Subject: RE: Application EP/45/21/HH

In the meantime it is my intention to amend the description of the application to read 'Retrospective application for retention of glazing to western side of existing balcony'

West Elevation

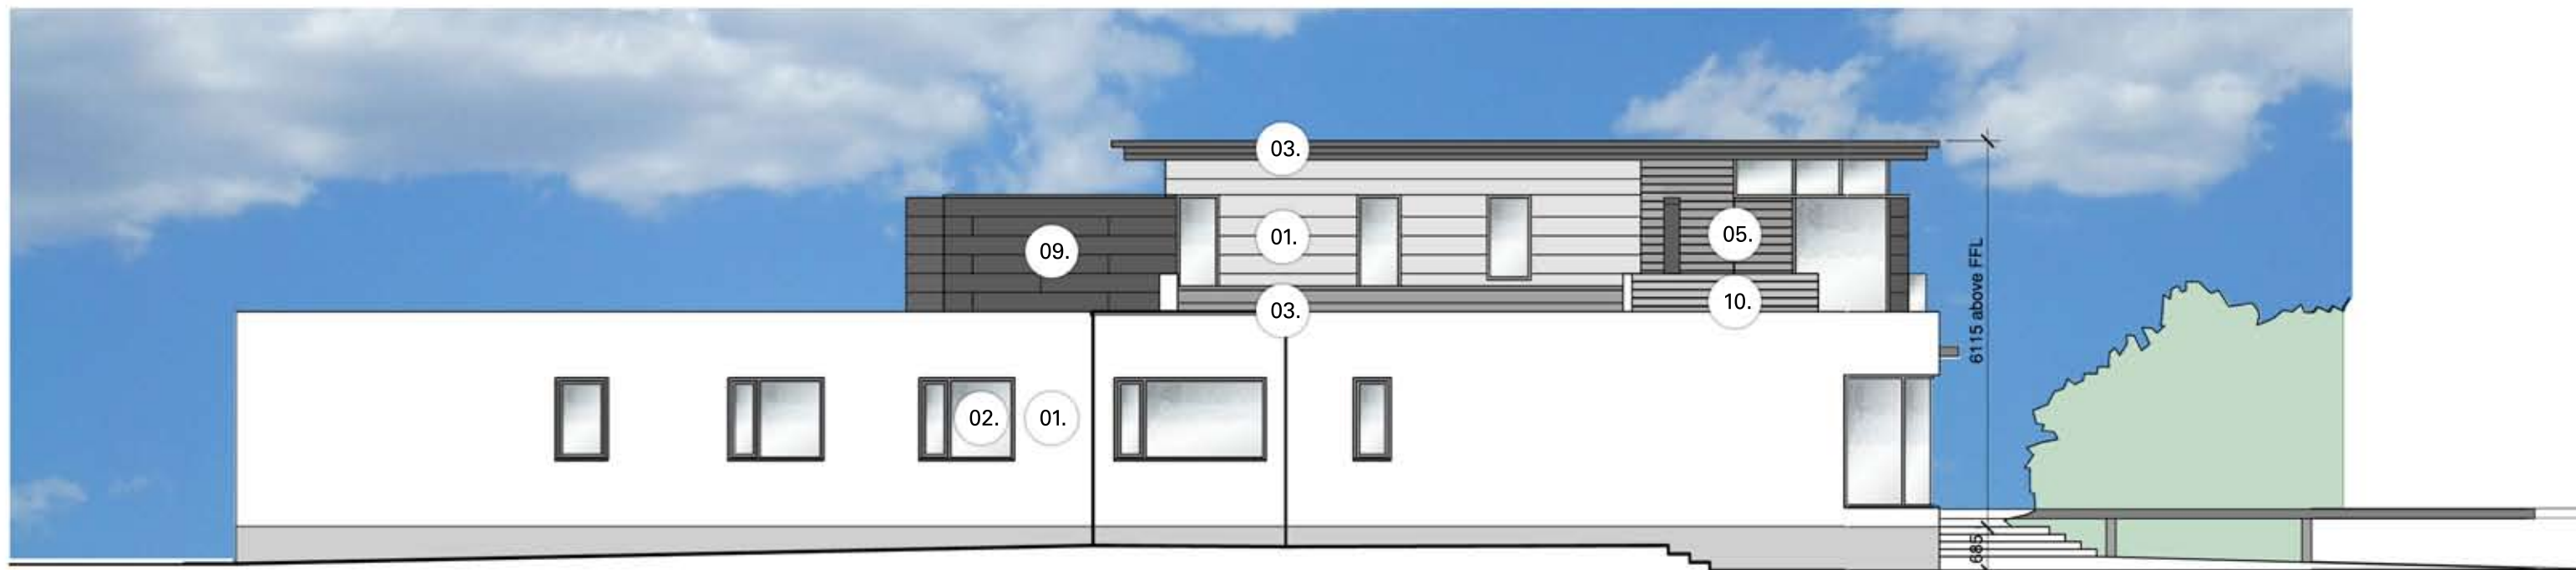
In order to ensure that the application plans are clear please can you let me have additional elevation plans which indicate the previous timber screen on the western elevation so that it is evident what alterations have taken place and what is being proposed. A clear before and after picture will enable the alterations to be precisely illustrated. I would suggest the plans are annotated existing/previous elevations and proposed/as built. I would also appreciate the height of the screening noted on the existing and proposed elevations to clarify whether the height of the structure has altered. A cross section of the as built west elevation would be helpful to demonstrate the overall height of the end of the balcony in relation to floor height. If it is not 1.7m high additional screening is likely to be required.
